# Hampshire Water Transfer and Water Recycling Project

## Environmental Statement – Appendix 5.2 EIA Scoping Opinion

# **SCOPING OPINION:**

## Proposed Hampshire Water Transfer & Water Recycling Project

**Title**  
Figure 1.2  
Scoping Area  
Sheet 1 of 8

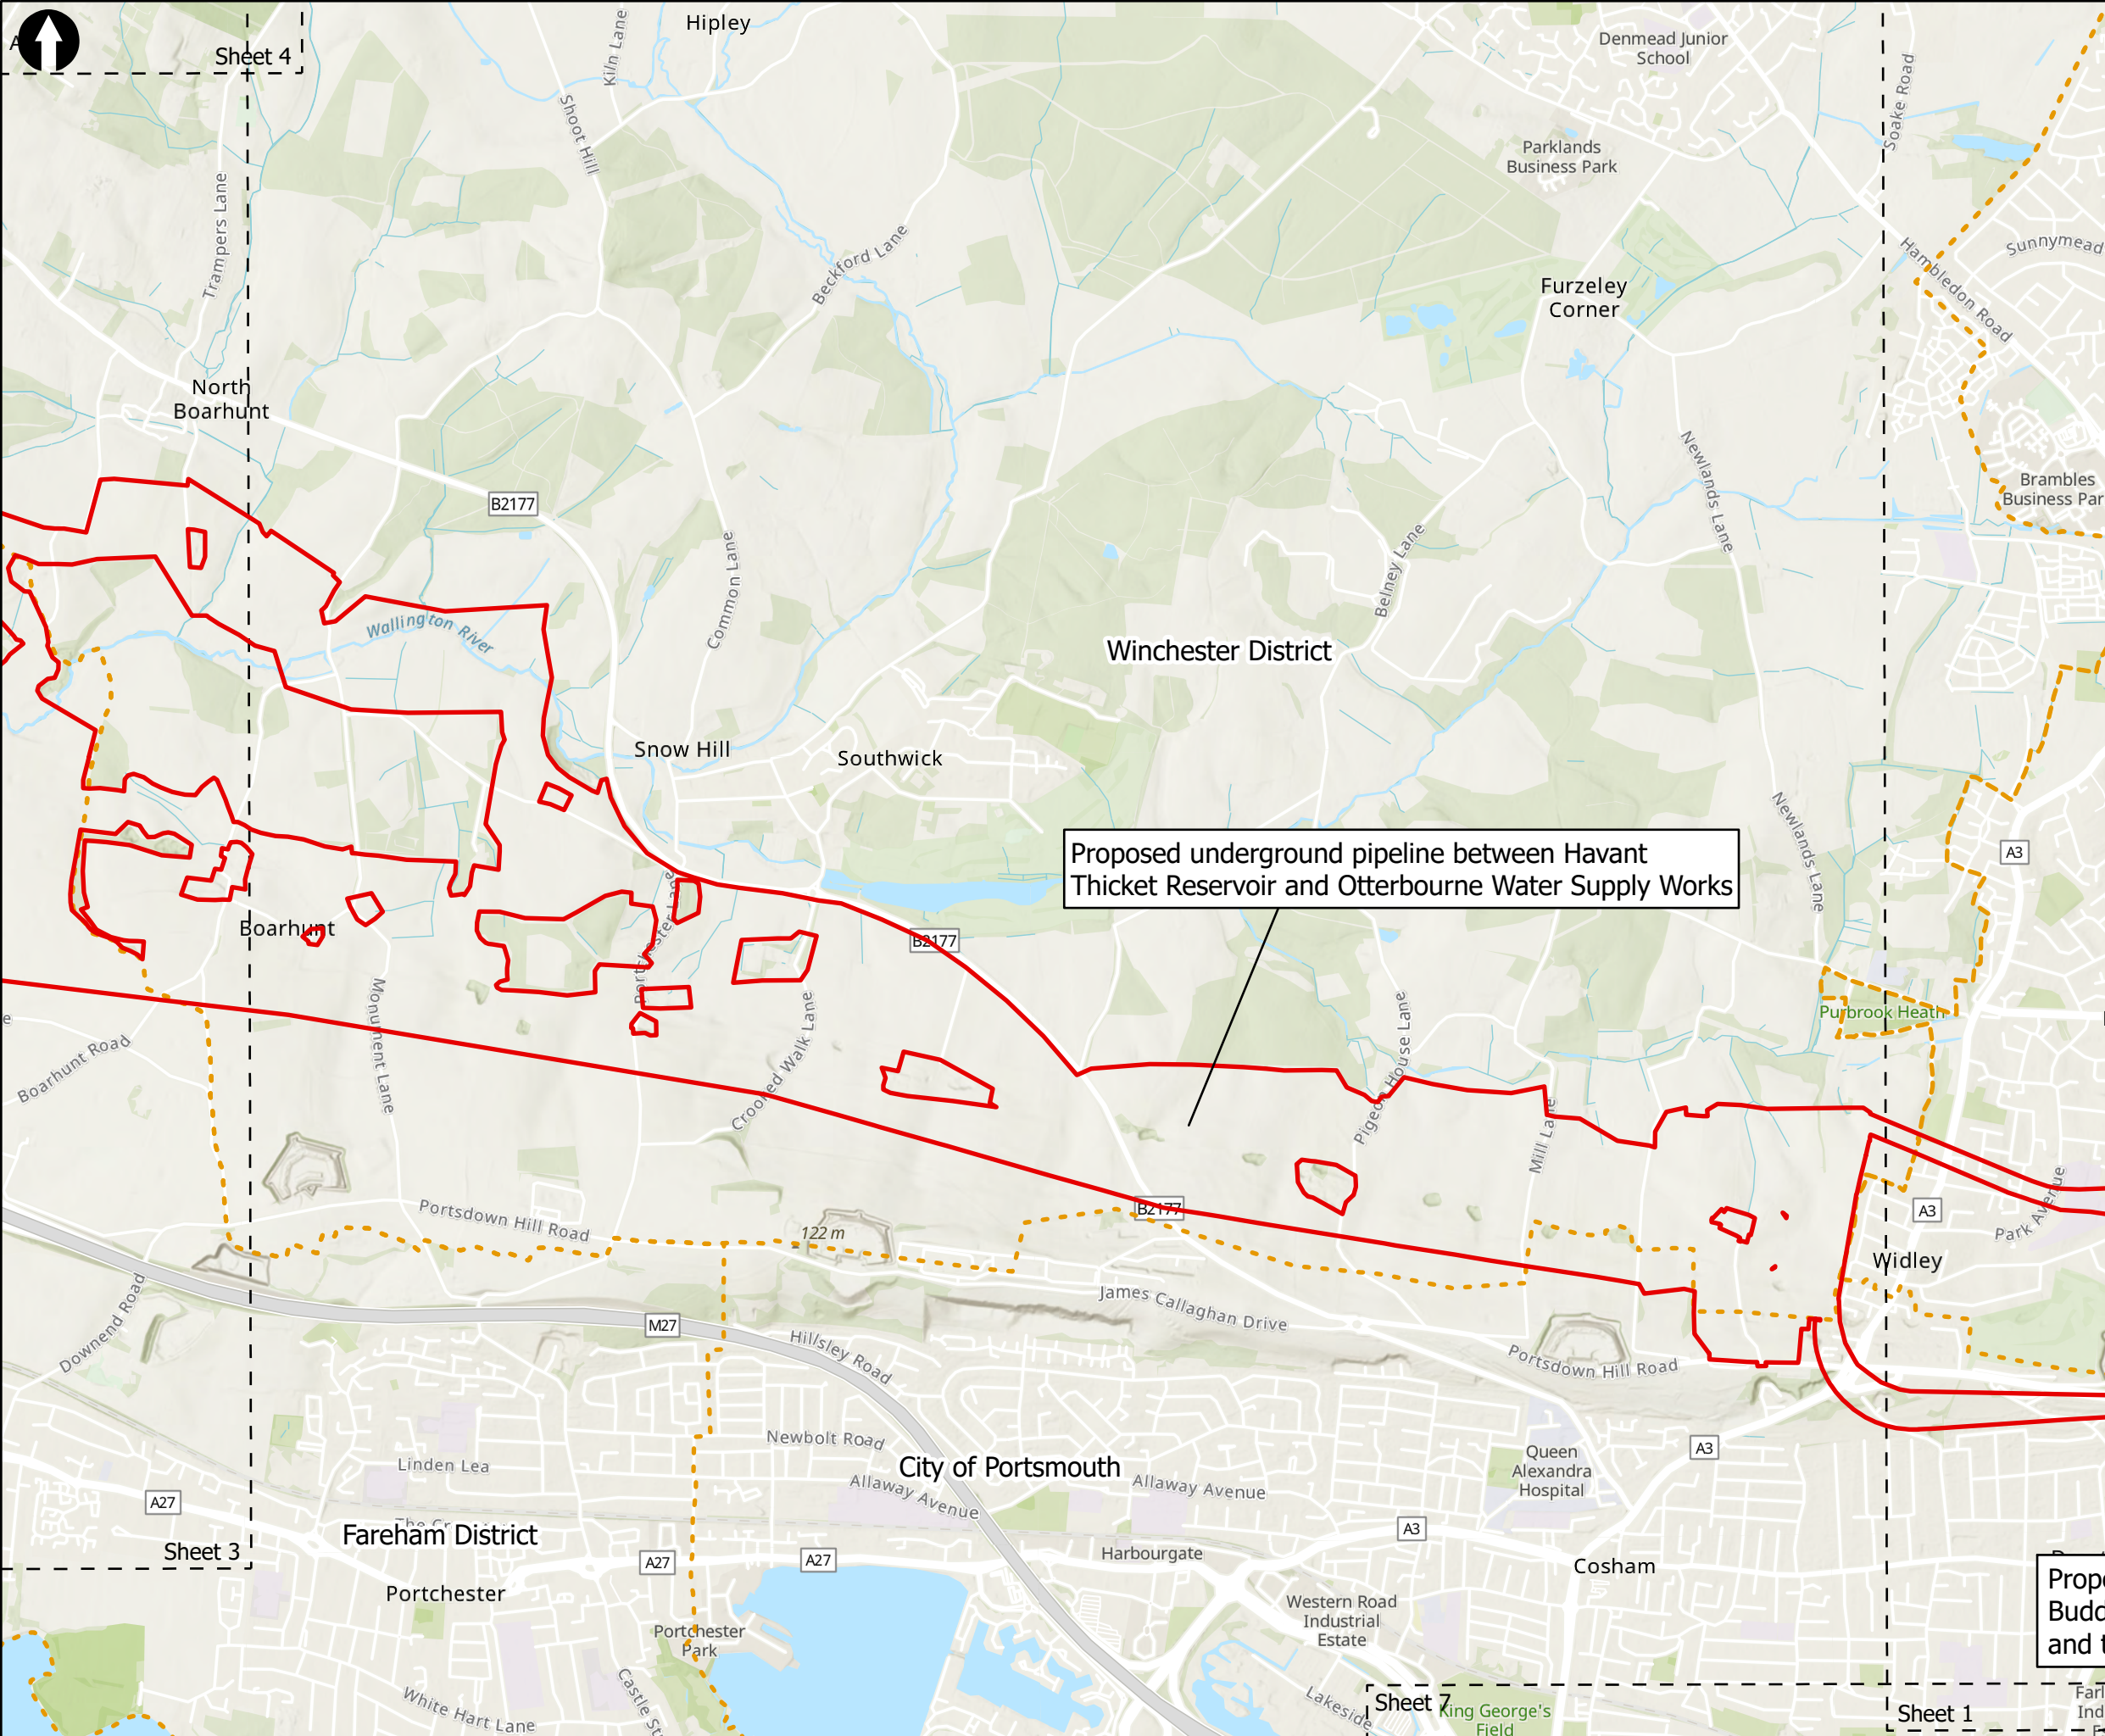
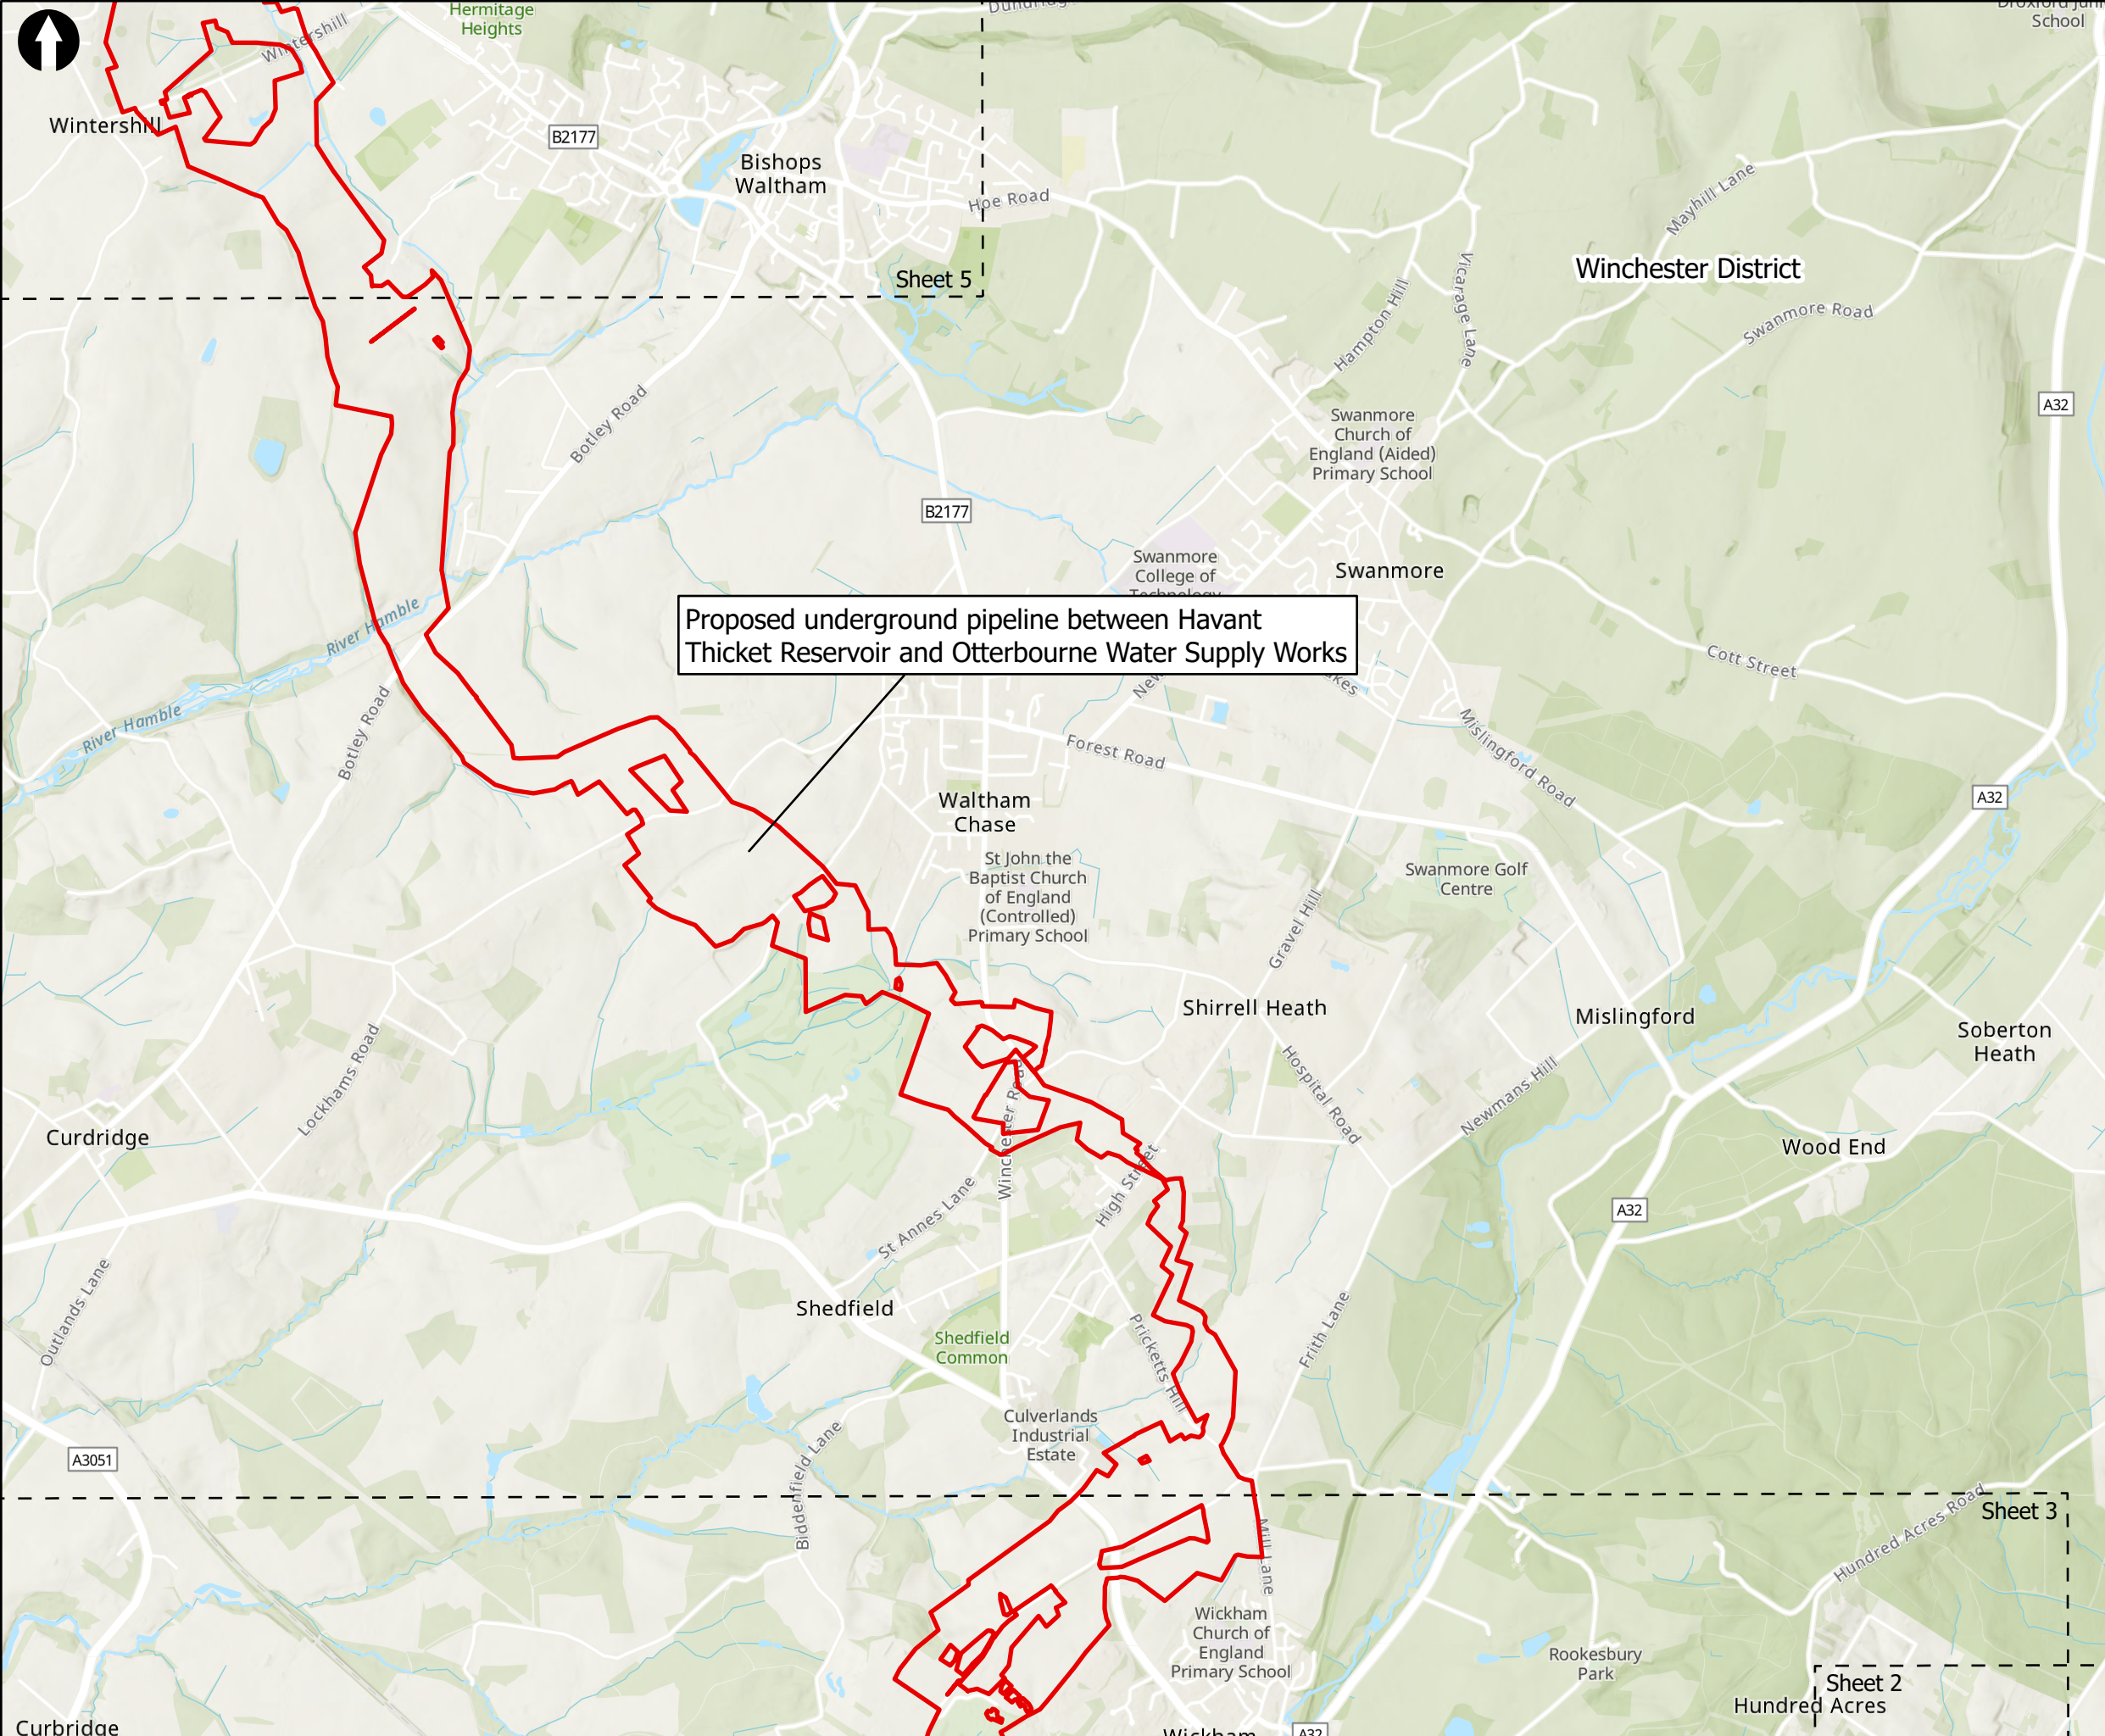
2.2.2	Chapter 4	Order limits	<p>The scoping area shown on Figures 1.1 and 1.2 is proposed to be refined further through scheme development and EIA processes prior to confirmation of the Order limits within the DCO application. The ES should include an explanation of any changes made following scoping,</p>

ID	Ref	Description	Inspectorate's comments
			including how environmental effects have been considered in finalising the Order limits.
2.2.3	Chapter 4	Alternatives	Paragraph 4.1.4 of the Scoping Report references a separate document, Scheme Development Summary, from the Applicant's consultation in summer 2022, which provides further detail about alternatives assessed during the development of the project. The Inspectorate considers that this document should be submitted as part of the ES, eg as a technical appendix, together with any other relevant documentation that has been used to inform the consideration of alternatives through the Regulator's Alliance for Progressing Infrastructure Development (RAPID) gated process.
